Zoning Division
Marge Schmuckal
Zoning Administrator

August 7, 2001

RE: 167 Harris Avenue - 335-G-001 - R-3 Zone

Amelia Kurtz
 167 Harris Ave.
 Portland, ME

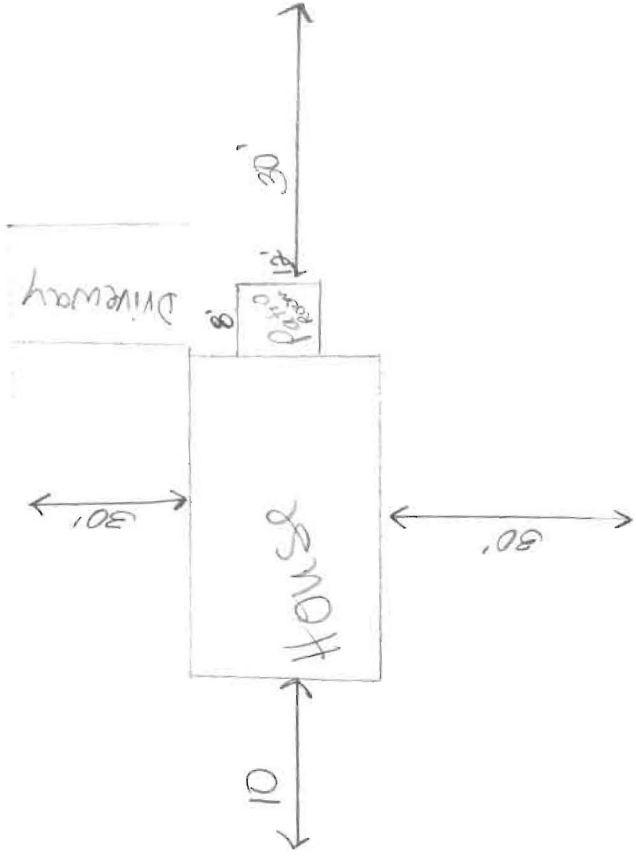
Recently it has been brought to my attention that the 8' x 12' deck and sunroom addition that was permitted and issued on April 11, 2000, was not constructed in the location noted on the submitted plans. Instead of a 30 foot setback on the left side of the principal structure, the deck and sunroom were constructed on the right side of the principal structure with a 16 foot setback, which abuts a paper street (Haskell St.).

Section 14-90 of the Zoning Ordinance requires a 20 foot side setback on a side street. 16 feet is being shown on a plan drawn by Livingston-Hughes Surveyors. Section 14-433 allows a reduction of side yards in the R-3 zone if the principal structure existed as of July 19, 1988. My research shows that the original house permit was issued in April, 1988 and that the principal structure existed as of July, 1988, so that this section of the ordinance may be applied.

I am allowing a reduction of the side yard from 20 feet to 16 feet using Section 14-433. This property is therefore not in violation of the zoning ordinance at this time. There is no appeal necessary.
